Application number: 2023/91280	
What is the application for?:	Quarrying operations for the extraction of clay, shale and incidental coal and s
Address of the site or building:	Bromley Farm Quarry, Barnsley Road, Upper Cumberworth, Huddersfield, HD8 8PD
Postcode:	S36 4HG

Type of comment: An objection	
Do you wish your comments to be published on the website anonymously?	Yes
<p>This objection is for myself as an individual , I will be submitting a further objection on behalf of the Cumberworth Quarry Action Group . I have limited these comments to the superseded documents and note the closing date is the 20th December , one day less than that quoted in the planning officers correspondence . I would point out that as the HGV route map was not sent until the 7th December , this timescale is exceptionally short and you are expecting residents to comment without the full context . A FOIA request made on the 19th September is well out of time and residents have been denied access to information between the council and developer . I'd also add its holidays , again !</p> <p>The new papers do not answer the questions rated red in previous papers and which formed part of an earlier response

HGV ROUTING PLAN

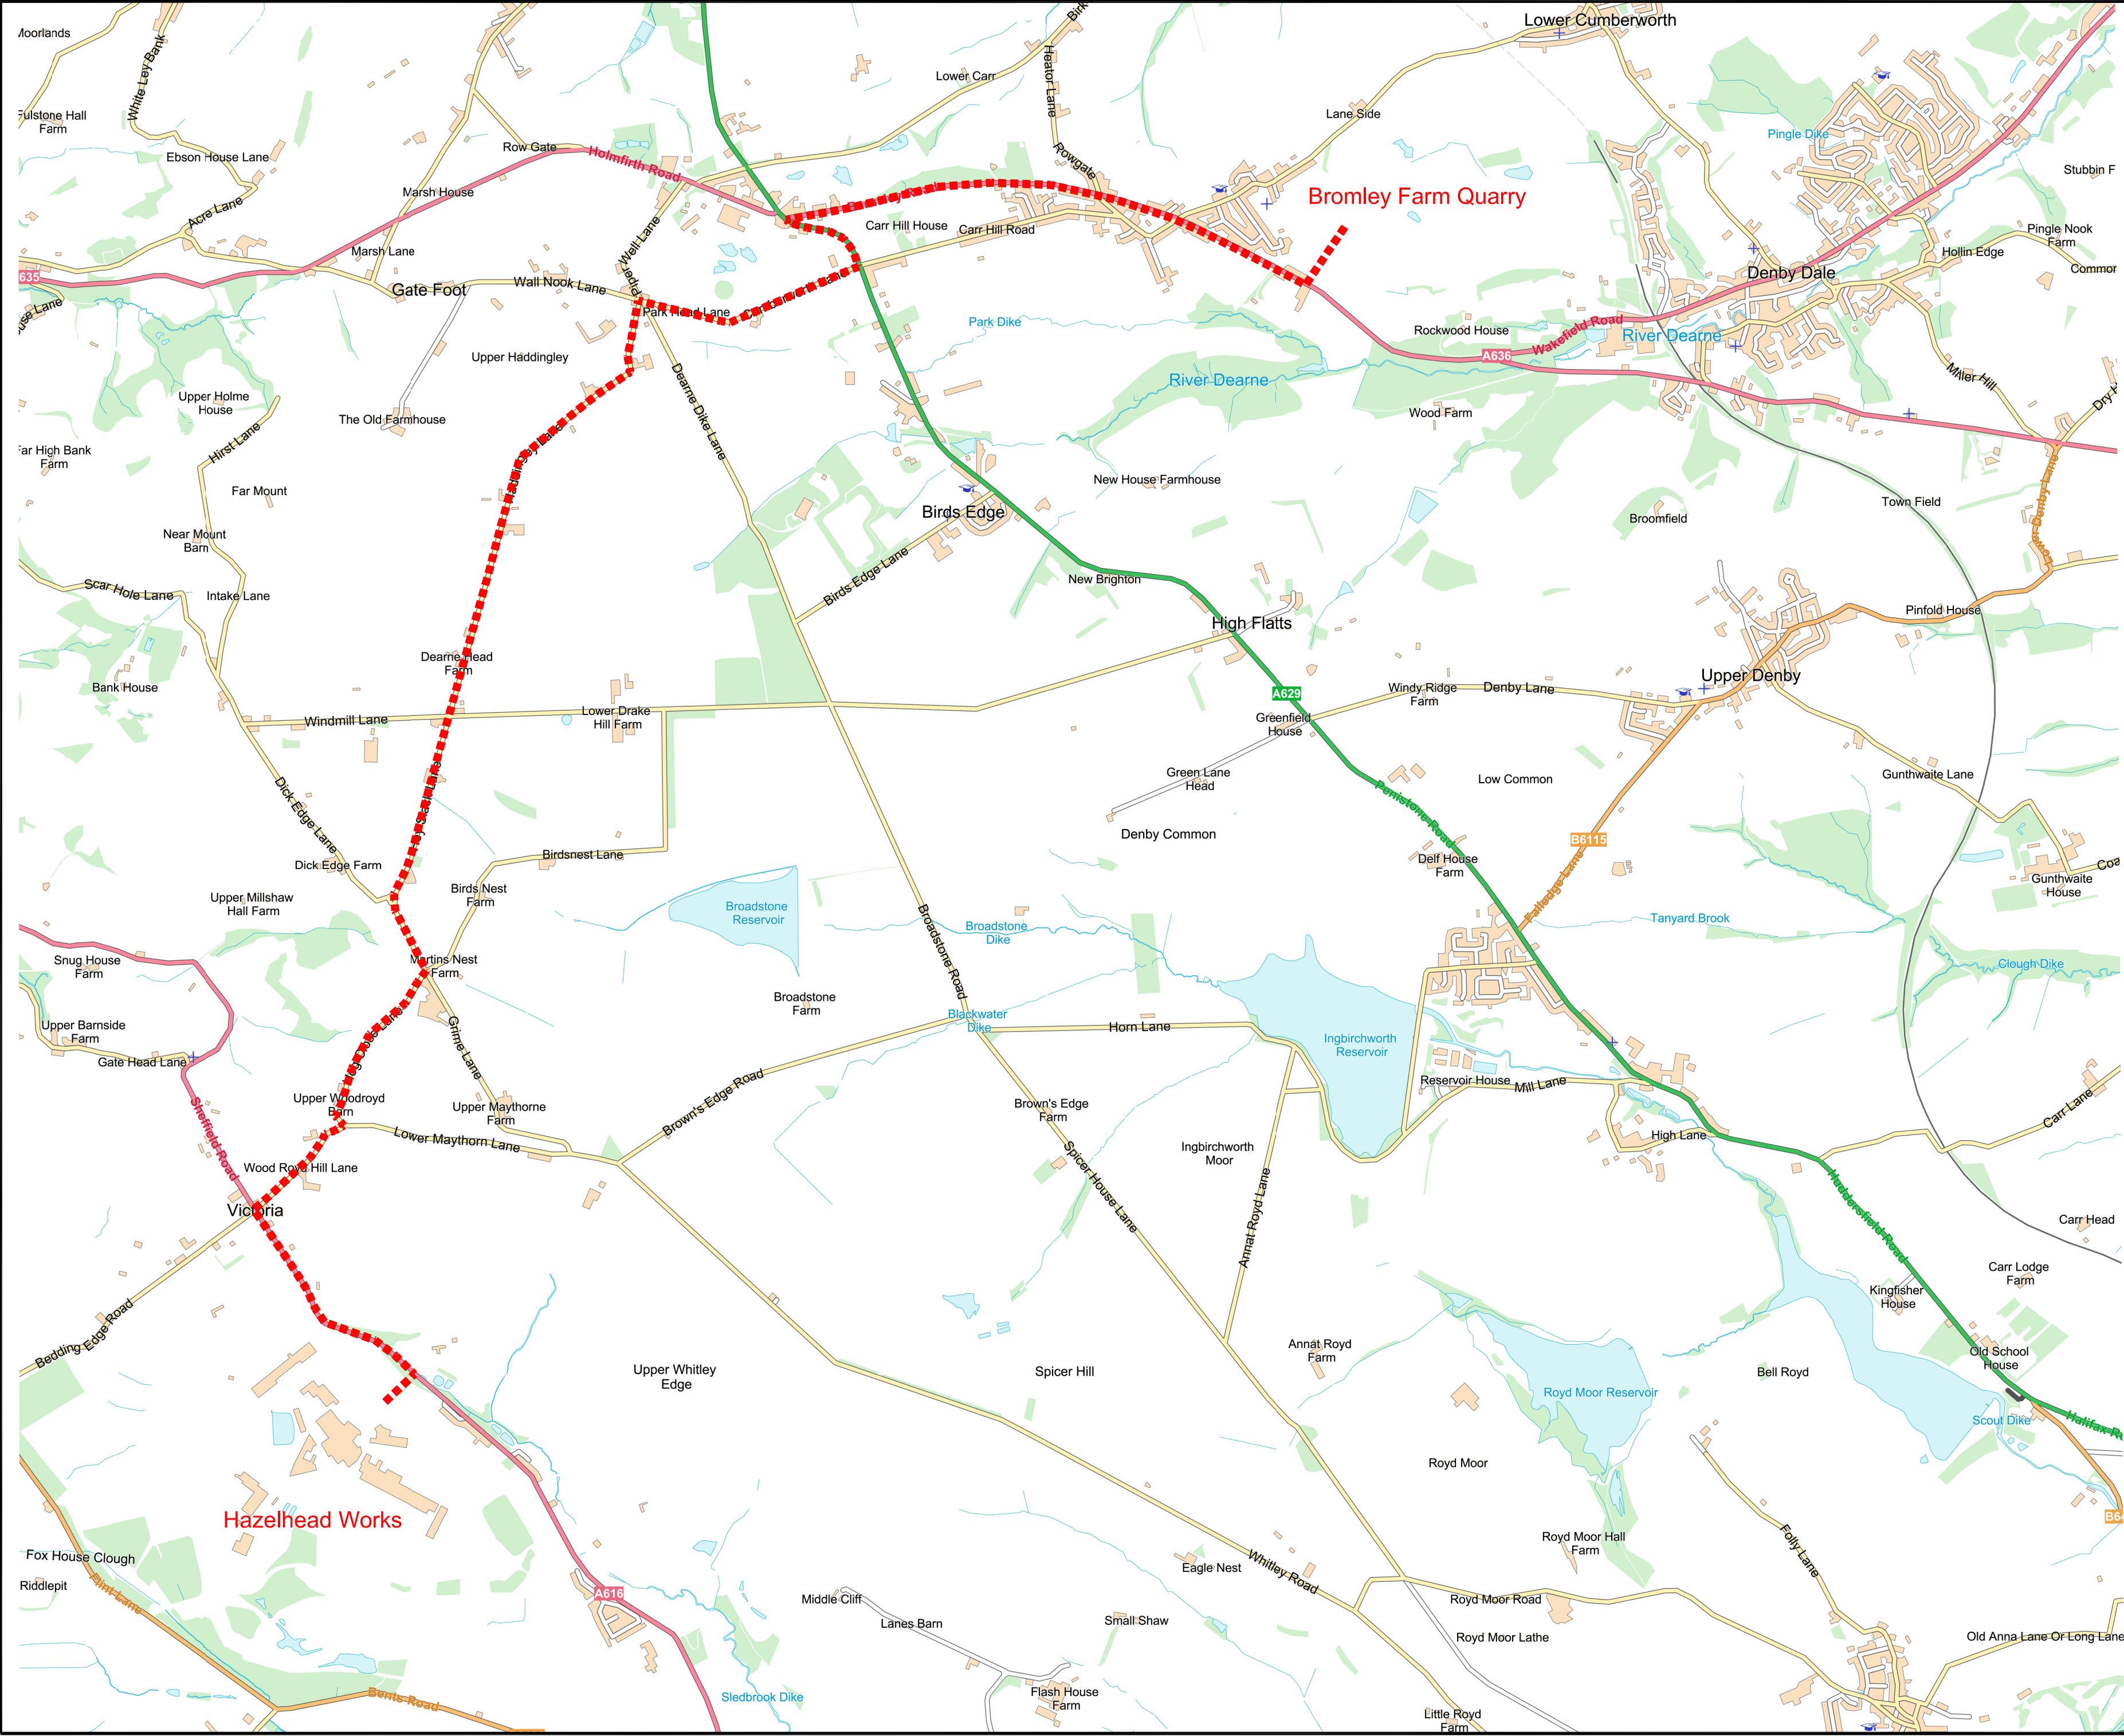
The use of the Sovereign Crossroads , a notorious accident spot , remains unassessed, by any of the traffic reports submitted . The council is well aware of the challenges that exist where the A629 and A635 intersect , indeed you have been discussing reports on this section of the highway on a regular basis since 2005 . There have been multiple accidents as vehicles turning left transgress into the oncoming traffic.

We know that currently , vehicles are using Carr Hill Road , as an alternative to a left turn at the Sovereign , it is totally unsuitable with no pedestrian walkway and is a route used by walkers and horse riders , it is likely that this will continue to happen going forward. The issue of traffic , speeding and rural roads is a real concern , we have sent the planning officer video evidence of repeated violations and unsafe practice by these vehicles . The community has also met with the police , and yet you have failed to consult with them regarding the safety of the highway and the route proposed.
